3. **Project# 1009375**  
12DRB-70252 MAJOR – SITE  
DEVELOPMENT PLAN FOR  
BUILDING PERMIT

H & W ARCHITECTURE agent(s) for MATTRESS FIRM request(s) the referenced/above action(s) for all or a portion of Lot(s) 13-21, Block 8, **NORTH ALBUQUERQUE ACRES Tract A, Unit B**, zoned IP or SU-2/ C and IP or SU-2/ NC, located on the east side of PAN AMERICAN FREEWAY NE between GLENDALE AVE NE and ALAMEDA PL NE containing approximately 6.7438 acre(s). (B-18)[*Deferred from 9/12/12*]**INDEFINITELY DEFERRED.**

**HYDROLOGY DEVELOPMENT SECTION  
DEVELOPMENT REVIEW BOARD MEMO**

DEVELOPMENT REVIEW BOARD – SPEED MEMO

Sheet Title:
SITE PLAN

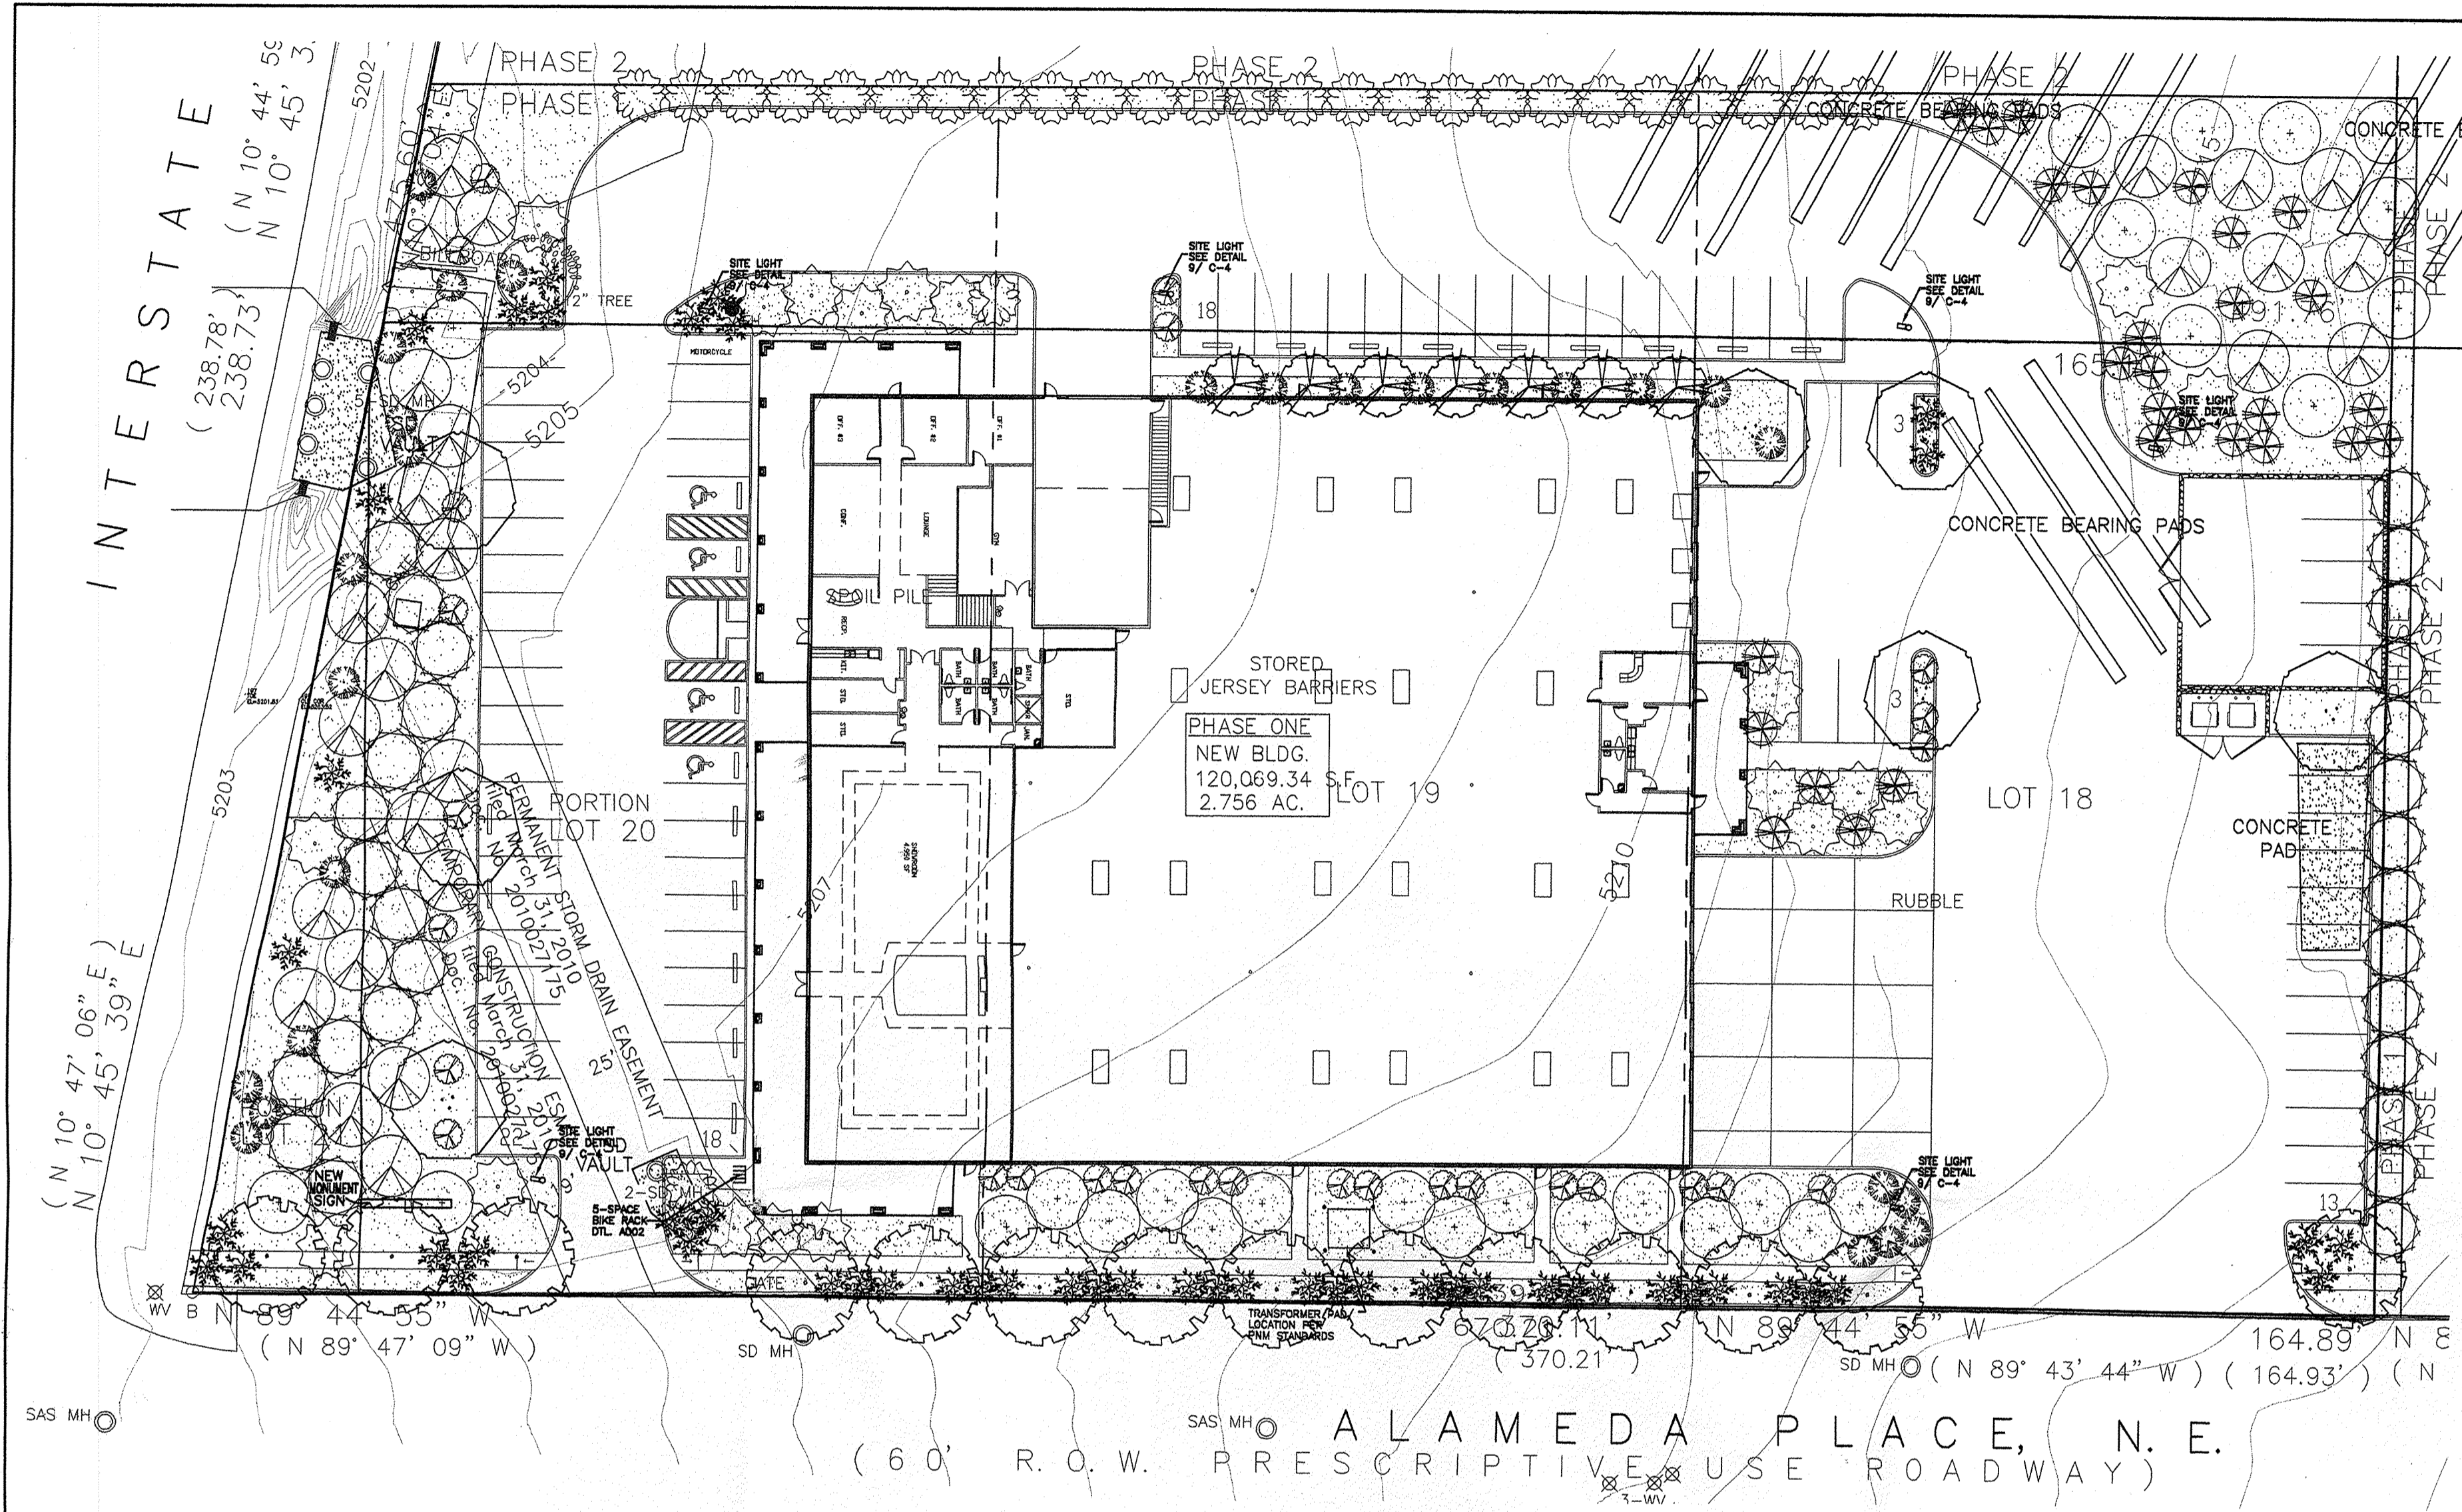
| <b>POLICE DEPARTMENT</b><br>DRB 1009375 - This project is in the Northeast Area Command.<br><br>- It appears the proposed landscaping (trees) and exterior lighting are in conflict with each other. Recommend removing from all trees that could eventually conflict with lighting. Mature canopy growth with reduce the illumination.<br><br>- Suggest including exterior video surveillance cameras in the plan. Cameras should be positioned to cover all parking stalls, walkways, vehicle access points and building entrances. Each camera should be monitored and recorded for real-time and historical use. |

Provide an exhibit showing the location of sidewalk and defining the distance from face of curb to the property line. Right of way dedication may be required.

All public sidewalk located outside City right of way must be located within a public sidewalk easement. A 50-foot wide drivepad is the maximum permitted (see *Development Process Manual*, Chapter 23, Section 6, Part B).

San Pedro Drive is classified as a collector roadway. Per the *Future Albuquerque Area Bikeways and Streets Plan*, 80 feet of right of way is required in this area.

Is there a replat associated with this site? If lot consolidation is not proposed, cross access easements are required.

A 6-foot wide, ADA accessible pathway is required from the roadway to the building.

For passenger vehicles, the minimum end island radius is 15 feet.

Define the width of all ADA accessible parking stalls and aisles.

Sidewalk (6-foot wide) is required along the frontage road.

Define the width of all right of way adjacent to this site.

Define the width and length of all parking stalls.

Show all ramps and provide details.

Label Glendale Avenue.

Show all lot lines.

Define all aisle widths.

**1 CONCEPTUAL GRADING AND DRAINAGE PLAN**  
1" = 30'-0"

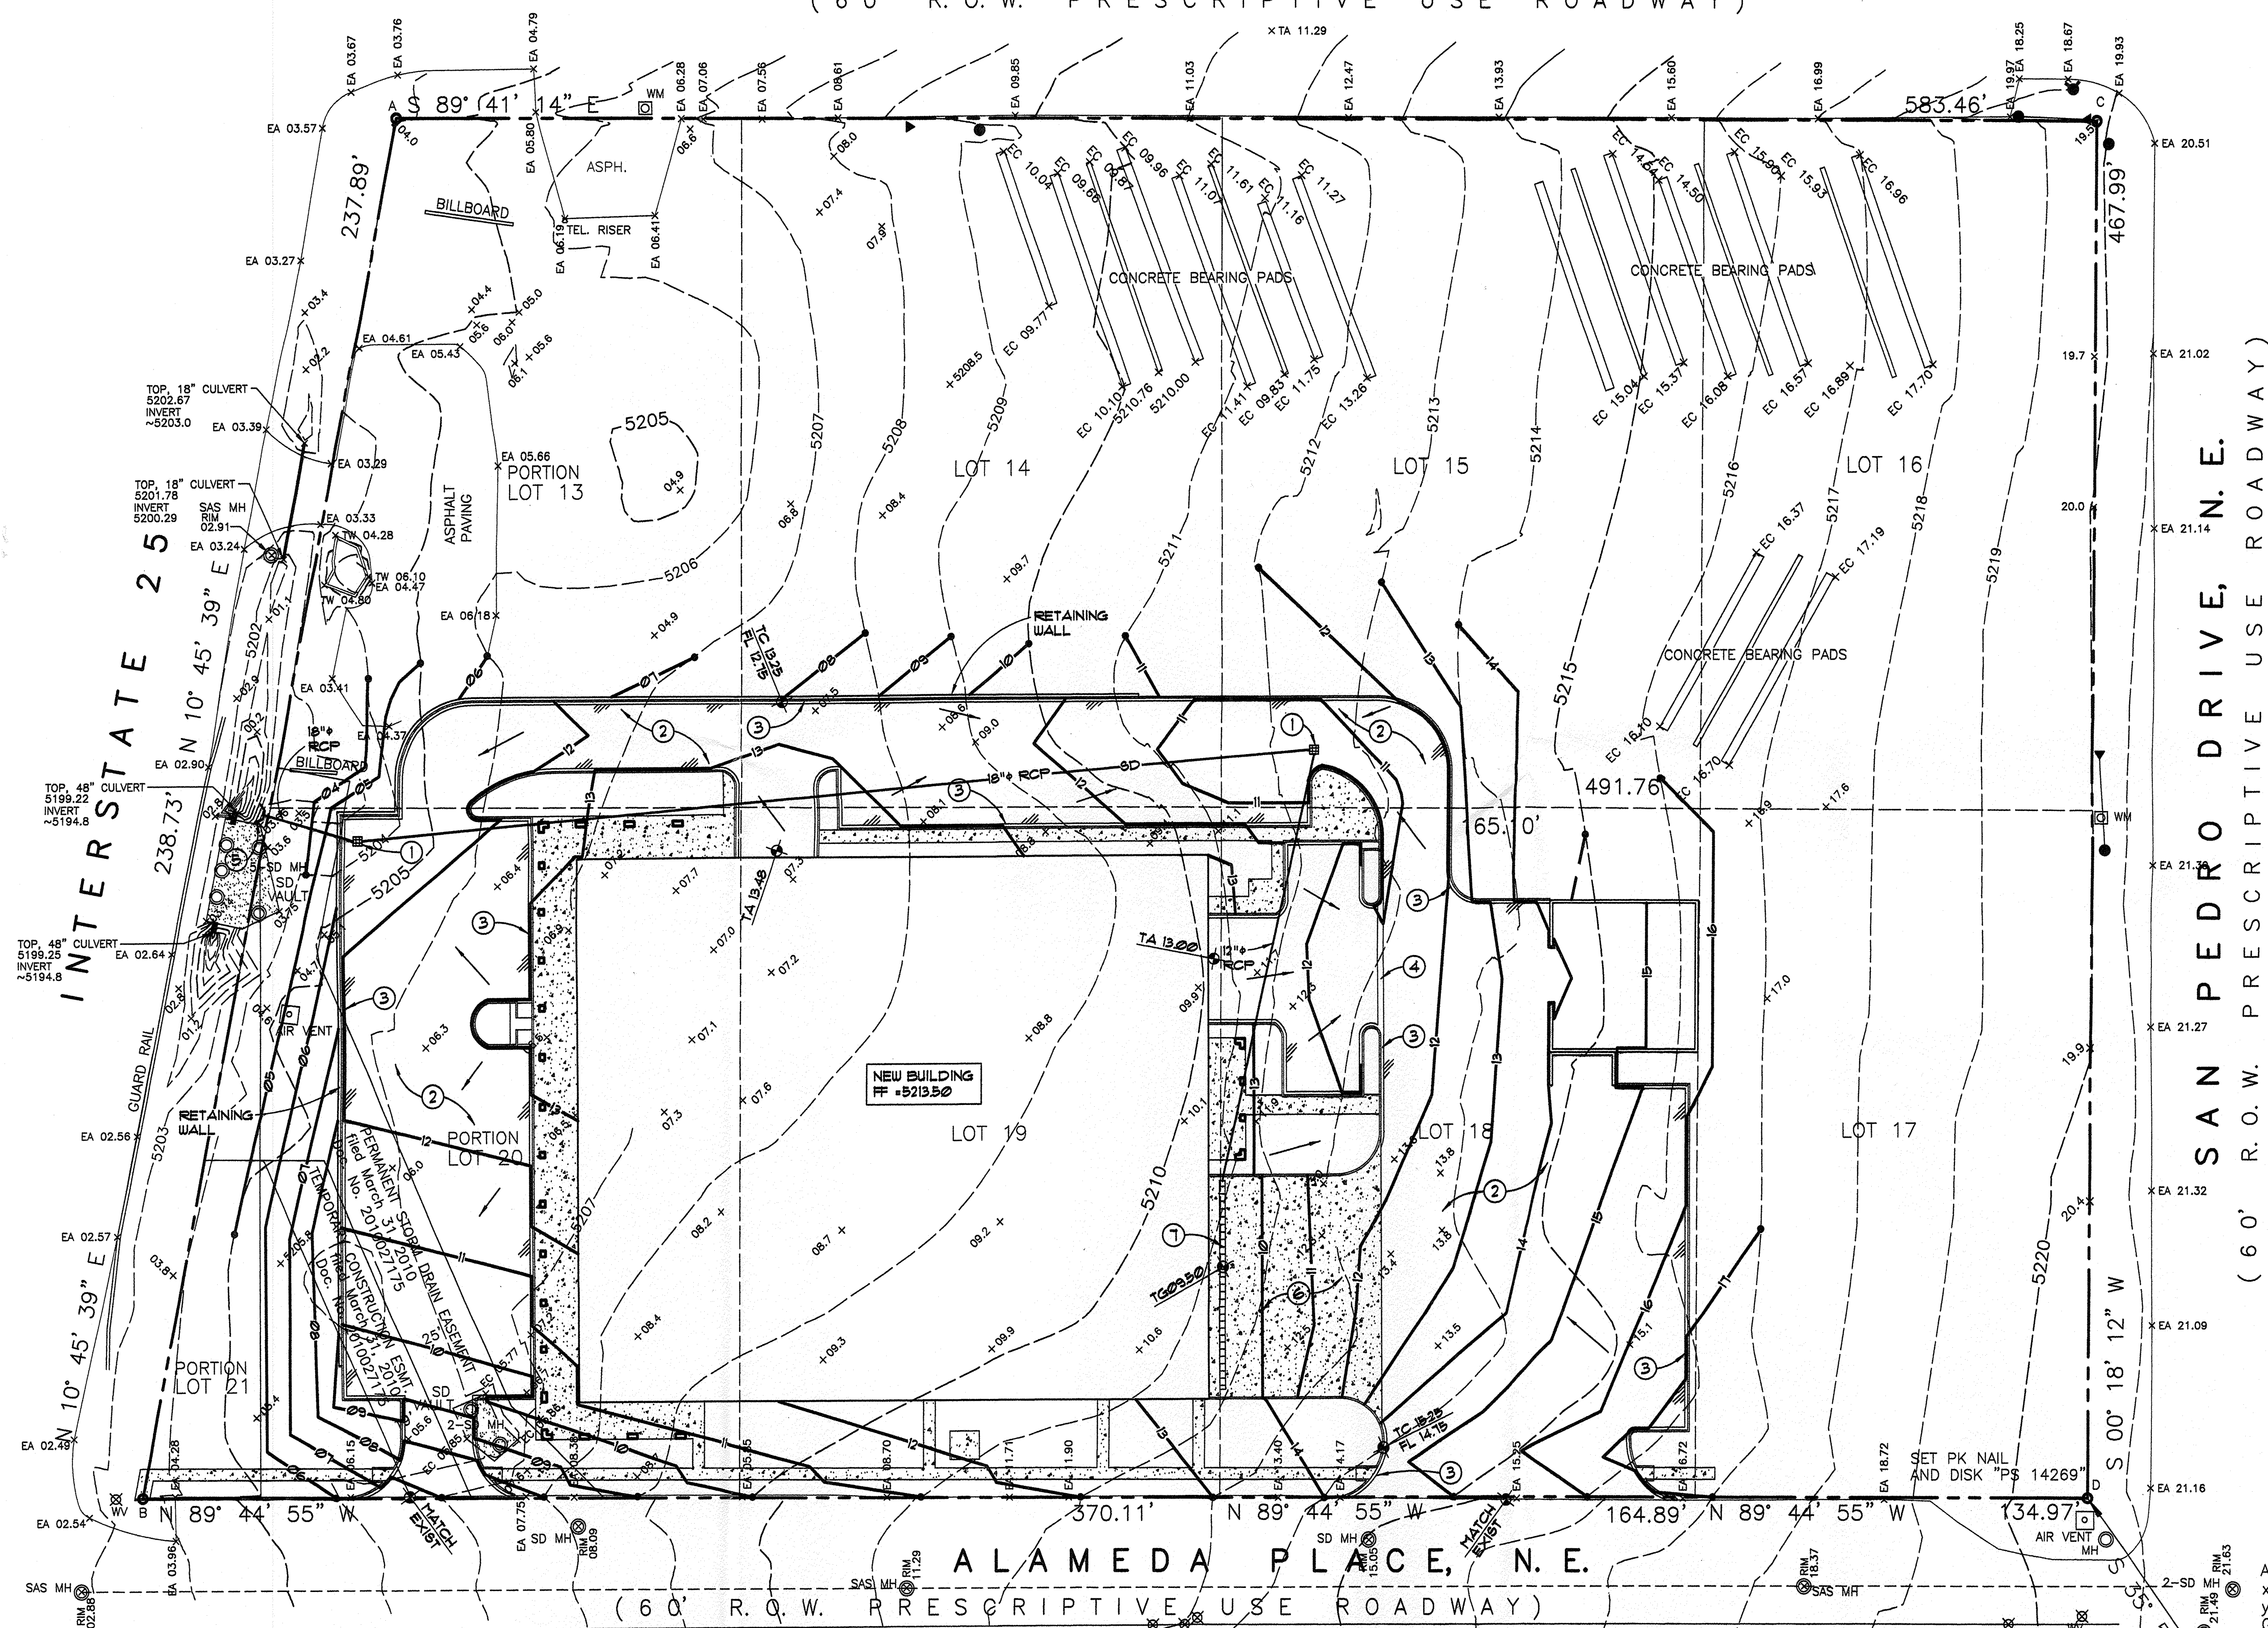
An approved Grading and Drainage Plan is required.  
NM DOT approval will be required.

Will this property be re-platted? There are existing  
Lot lines in the middle of the building.

What is north portion of the site being used for.
